**KIRKLEES METROPOLITAN COUNCIL
INVESTMENT & REGENERATION SERVICE**

DELEGATED DECISION TO DETERMINE PLANNING APPLICATIONS

Reference No:	2025/62/93487/W
Site Address:	2, Belton Grove, Birchenclyffe, Huddersfield, HD3 3RF
Description:	Erection of two storey and single storey side extensions with rear dormer and associated alterations
Recommending Officer:	Joshua Merriman

Officer Report – 2025/93487

Side Elevation 1.100

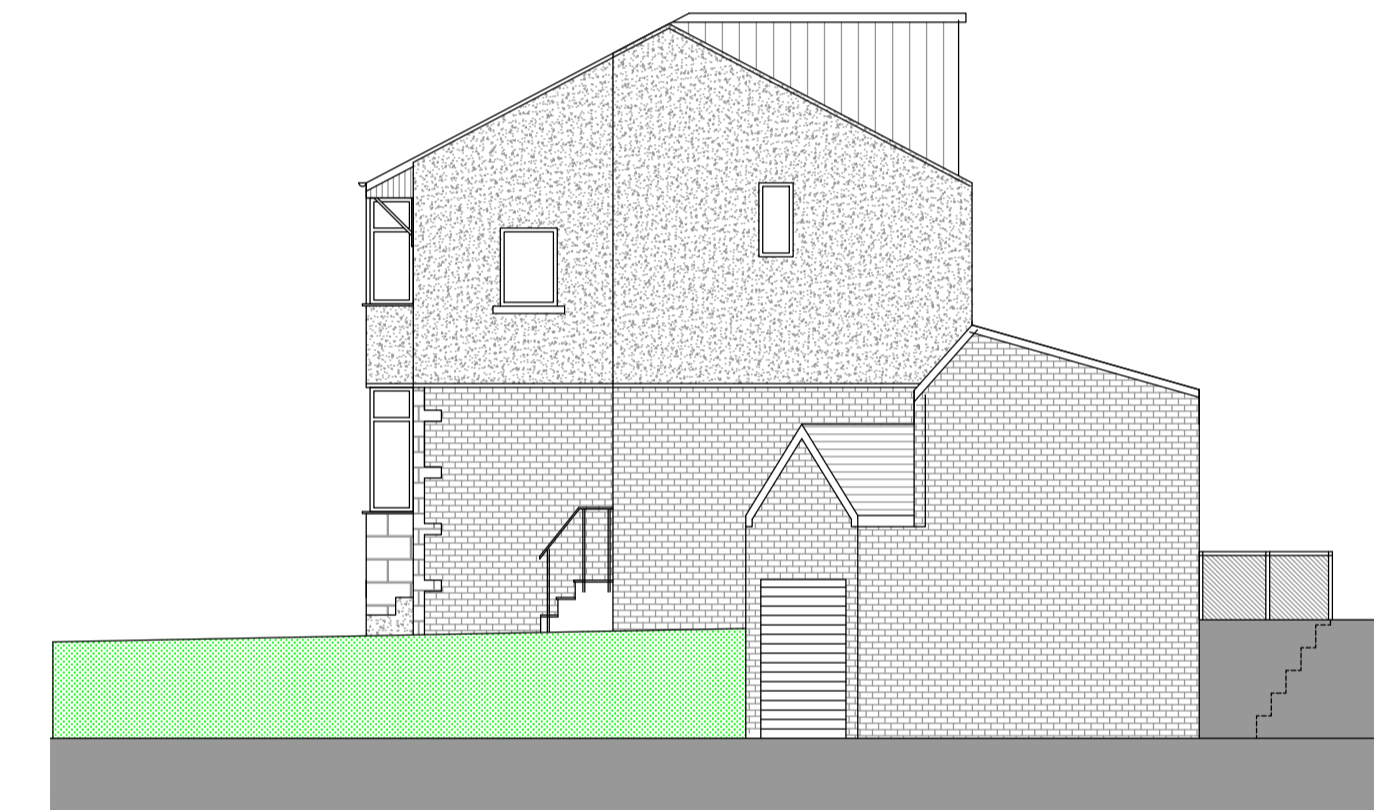
The amendments included reducing the width of the dormer to that of the original property, reducing overall height of dormer; squaring off the single storey side extension to increase visual appeal, an extended roof slope to the front elevation of the two storey side extension, removal of the window to the front elevation of the two storey side extension, windows changed to match those in the existing building.

- Concerns that the rear dormer extending directly to the shared boundary line would have an unreasonable impact upon the adjoined property and its development potential.

CLIENT	Maria Hafeez		
ADDRESS	2 Belton Grove Huddersfield, HD3 3RF		
PROJECT	Side Extension and Rear Dormer		
DRAWING	Proposed LG and GF Layout		
DRAWN	UH	DATE	Aug 25
		SCALE	1.50@A1
DWG No.	2542/02D		
STATUS	PLANNING

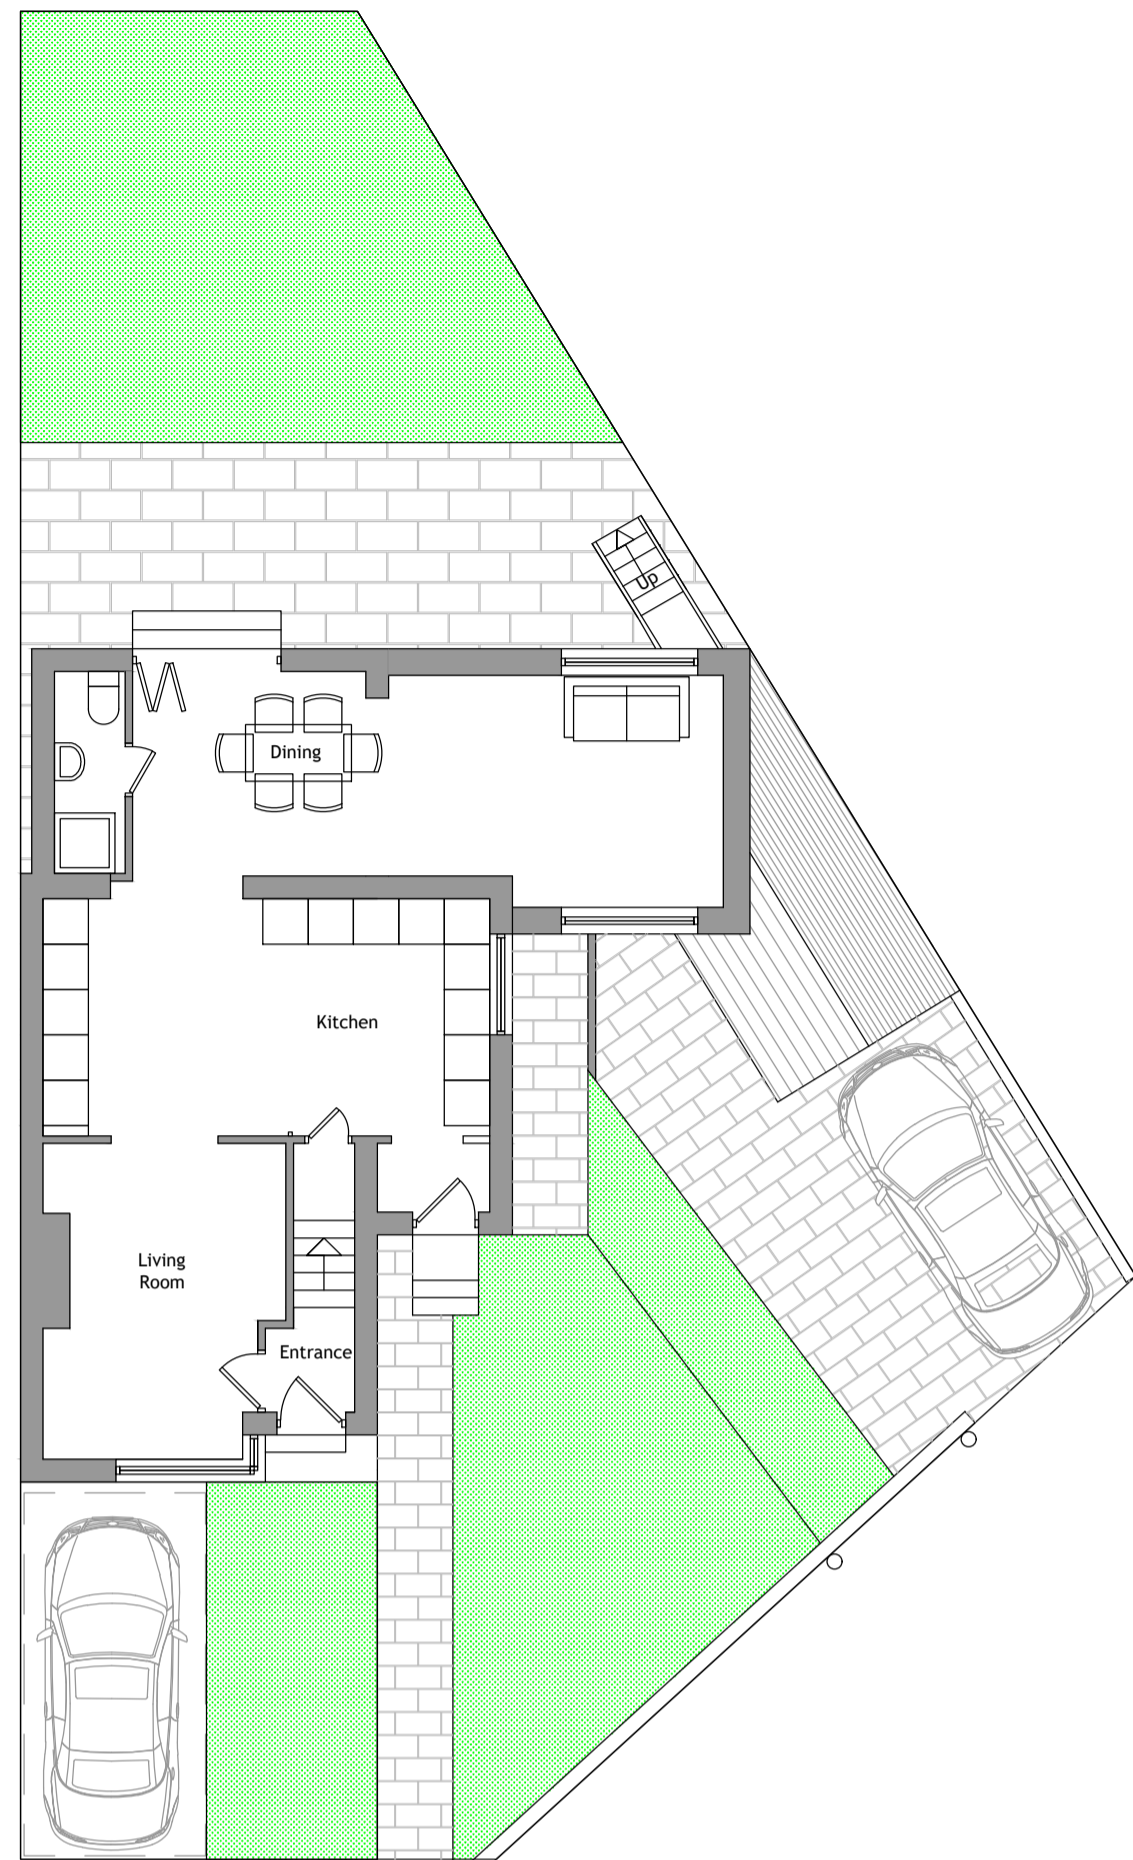
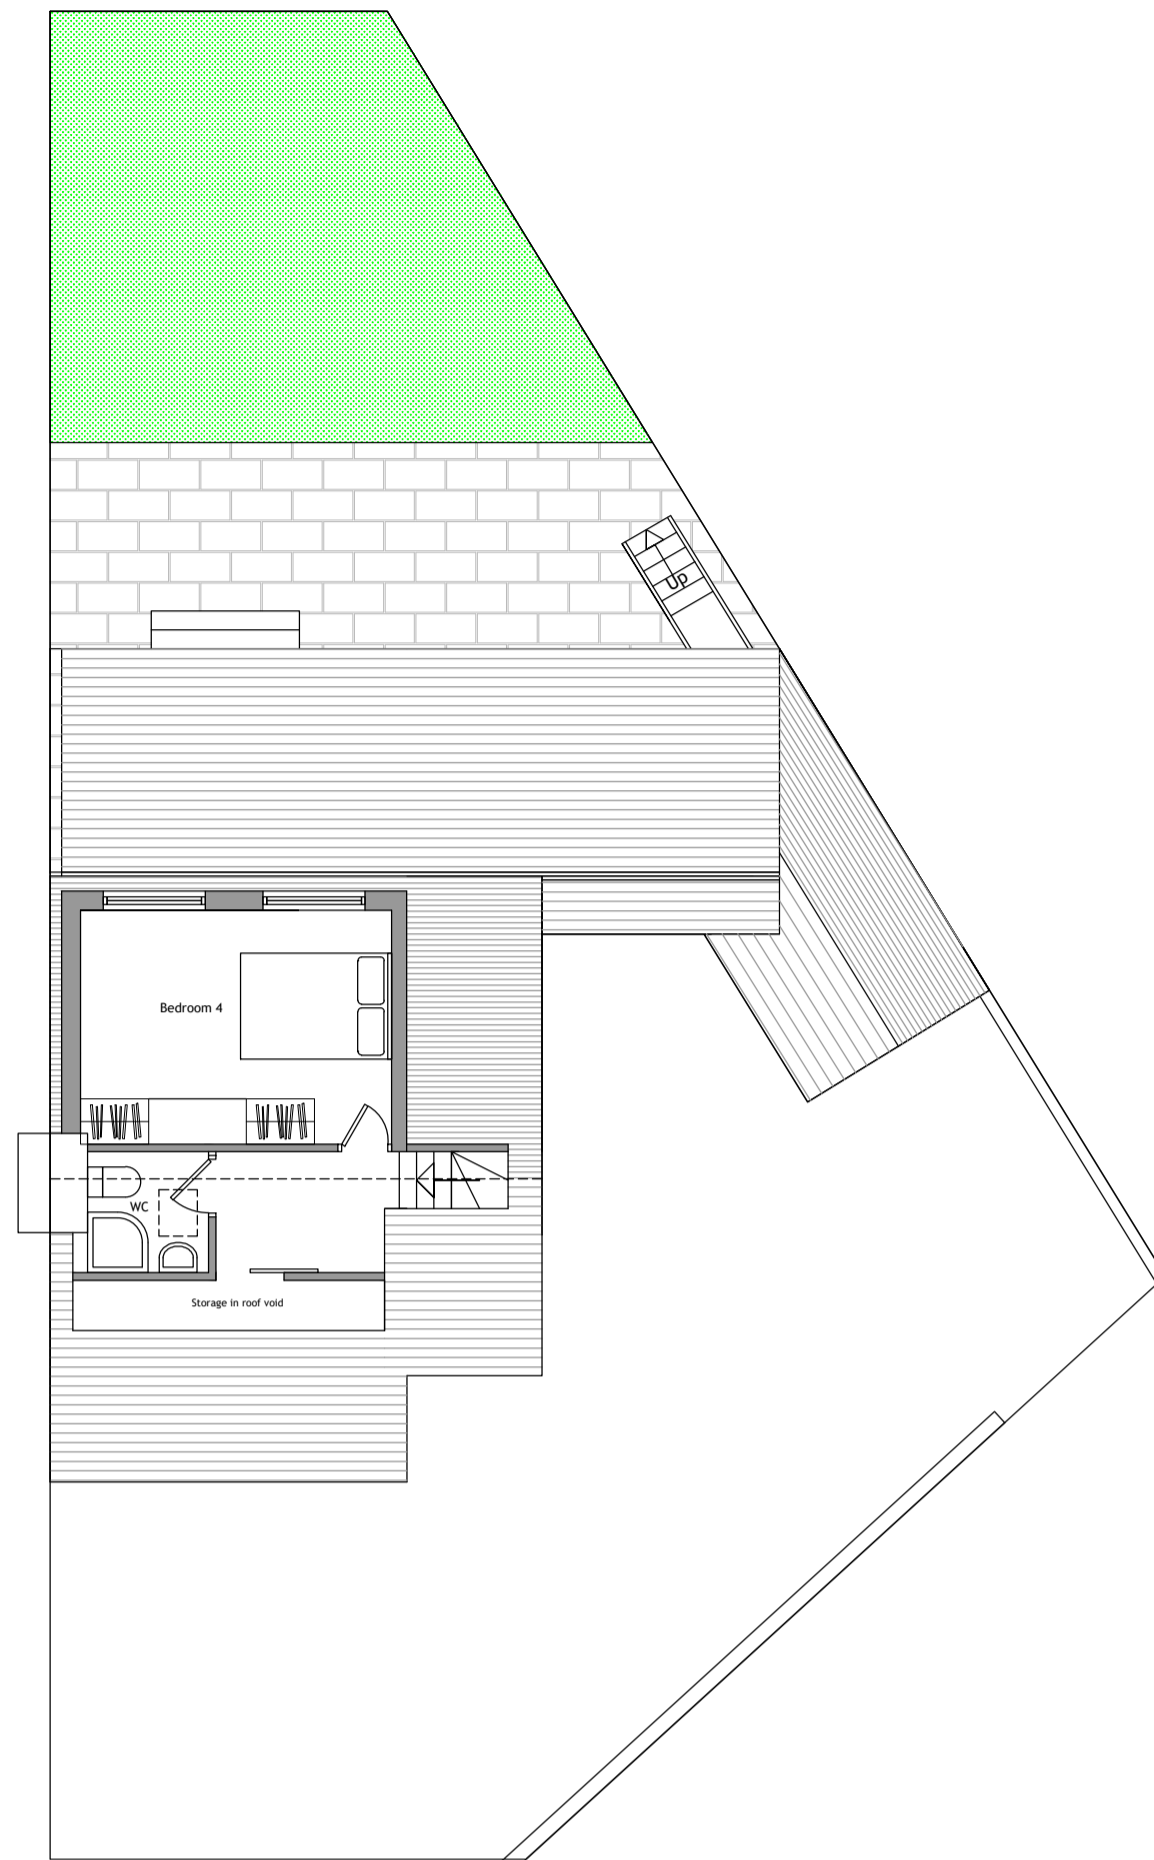
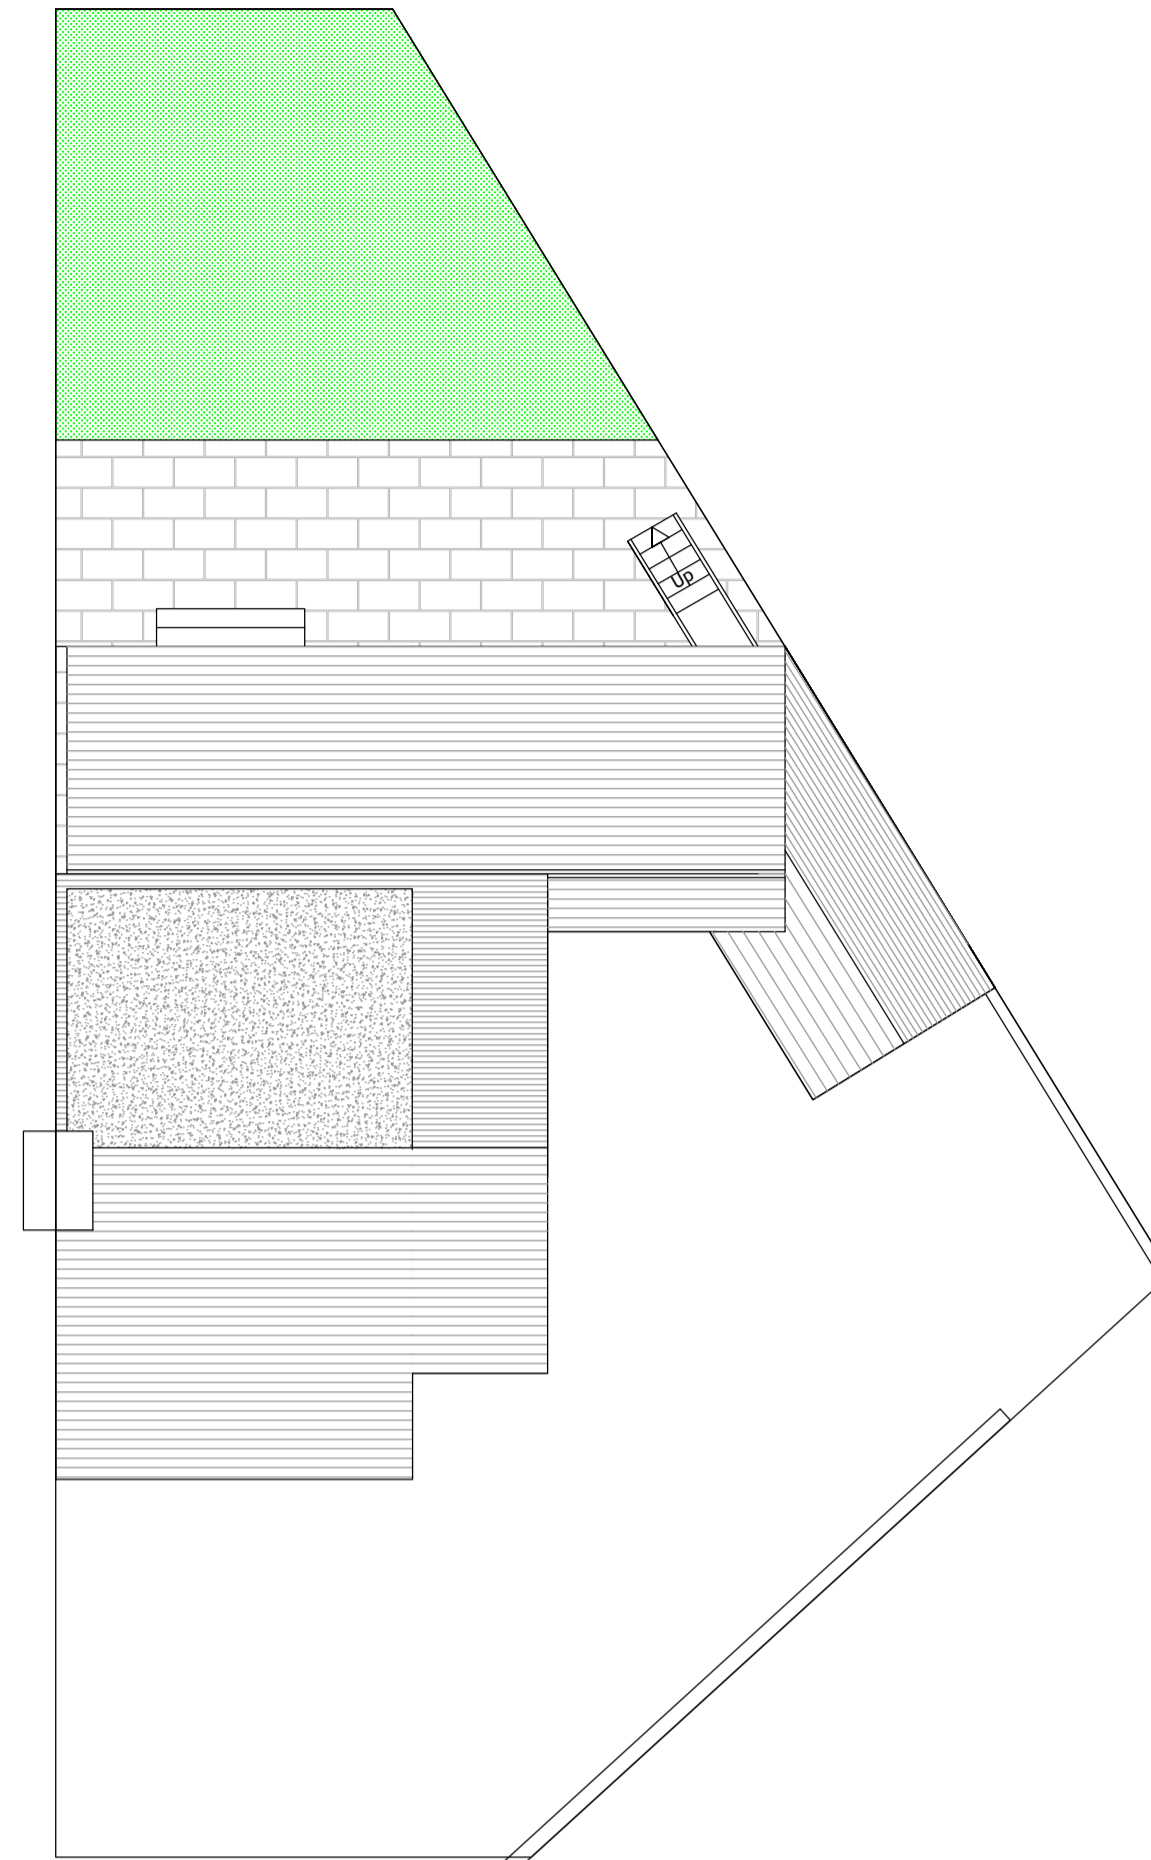
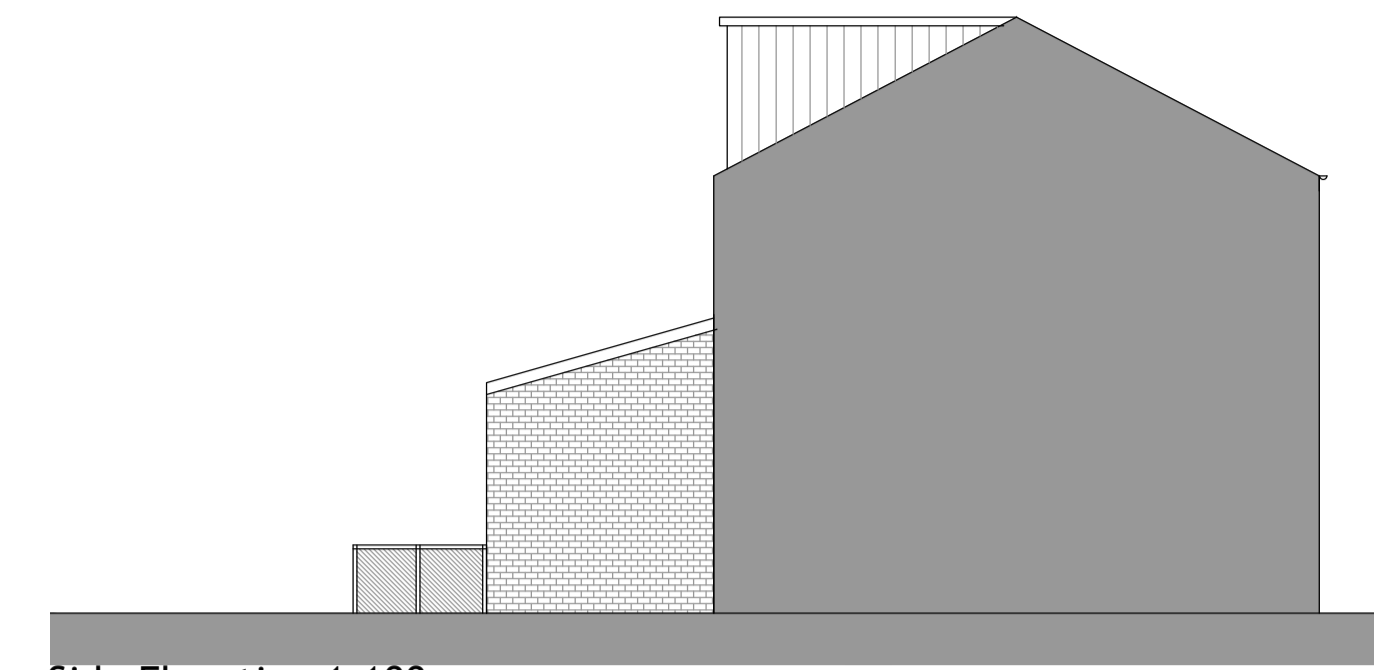
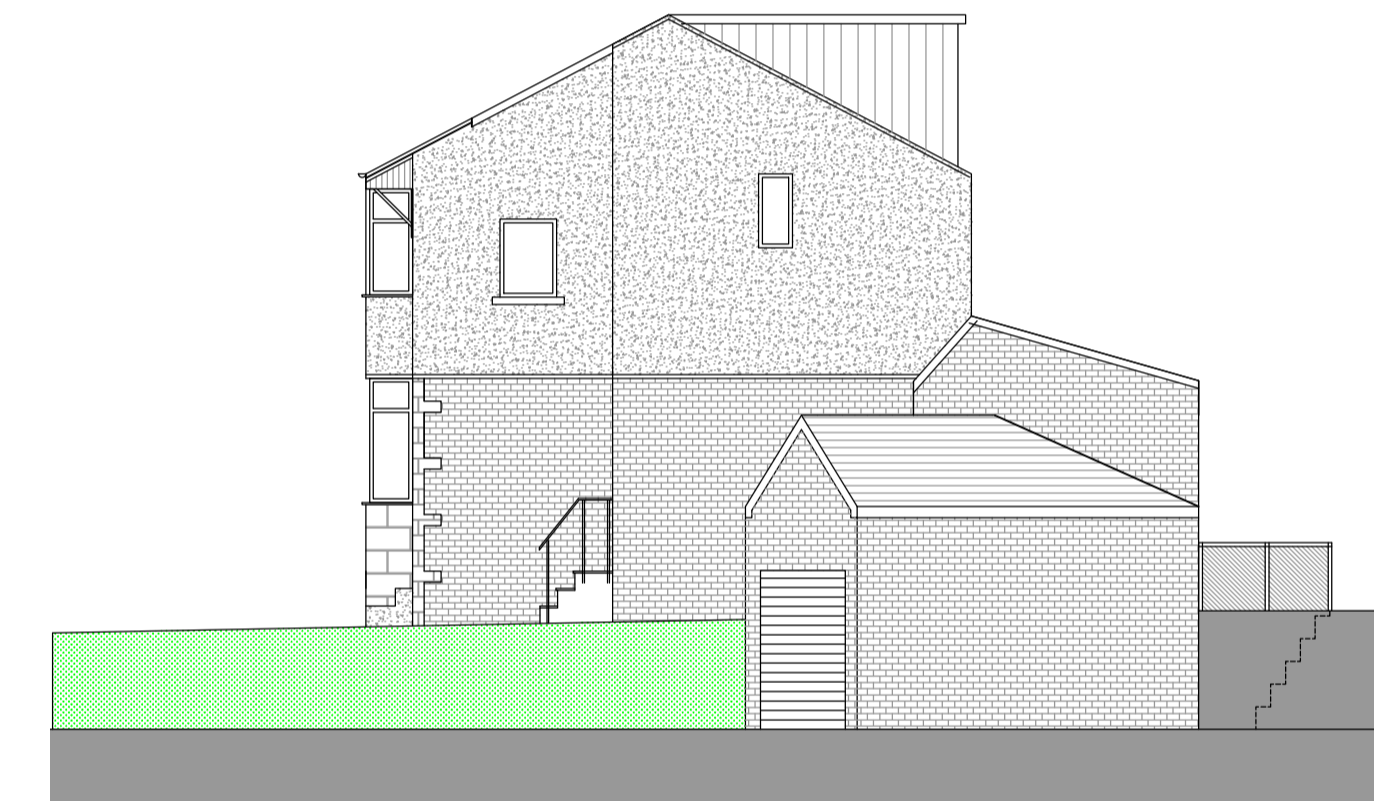
The proposed single storey side extension does not extend further than two thirds of the width of the original house and is constructed using matching materials.

The two-storey side extension is compliant with the relevant policies for two-storey side extensions as set out in the House Extensions and Alterations SPD, and as a result of the extension in roof slope and removal of front window is considered to be visually sympathetic to the host property and street scene.

Finally, the proposed rear dormer has been reduced in scale to no longer dominate the rear roof plane and is set below the ridgeline of the existing roof, appearing proportionate to the existing dwelling.
